MECKLENBURG COUNTY
Park and Recreation Department

MEMORANDUM

DATE: November 27, 2023

RE: Rezoning Petition #2023-046
PID# 22916101, 05, 03, 84

SCHEMATIC SITE PLAN

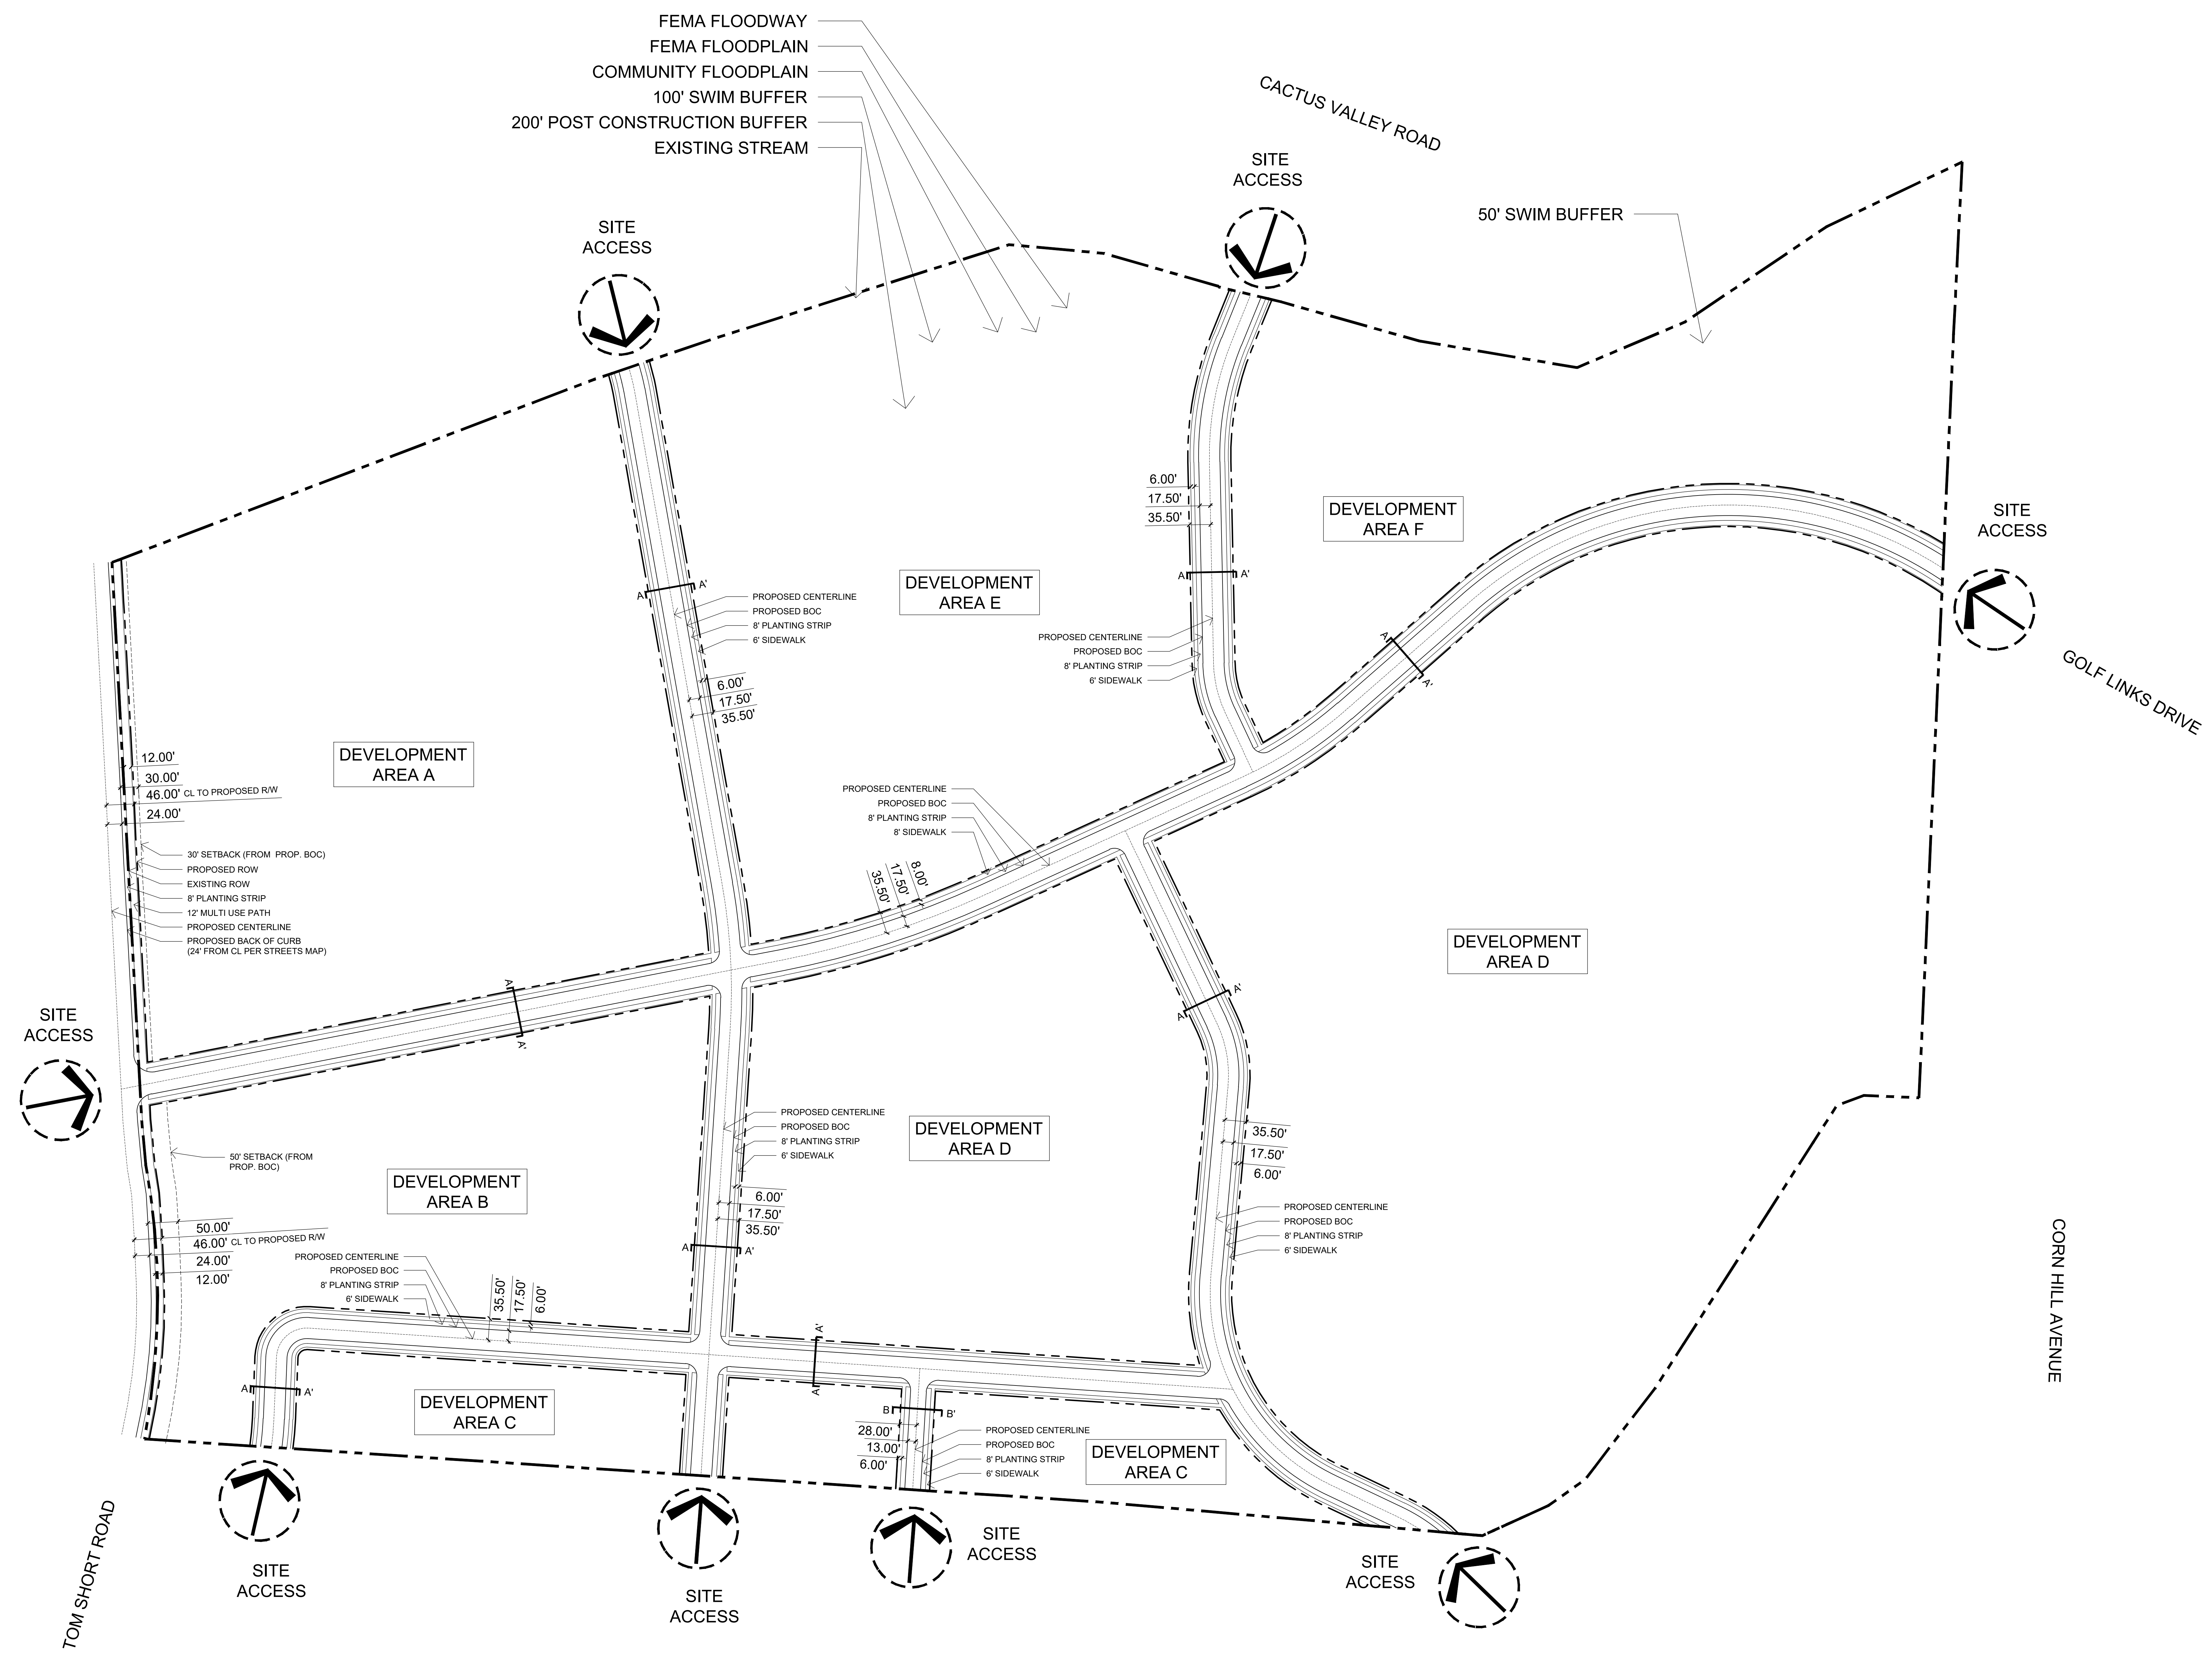
MCPR requests minimum of **2.0** acres to be dedicated and conveyed to Mecklenburg County for a future local park on the East side of the development. This requested park land shall be adjacent to a public right-of-way for access and is conducive for the development of the typical amenities found in a local park and cannot include tree save parcels or stormwater BMP's.
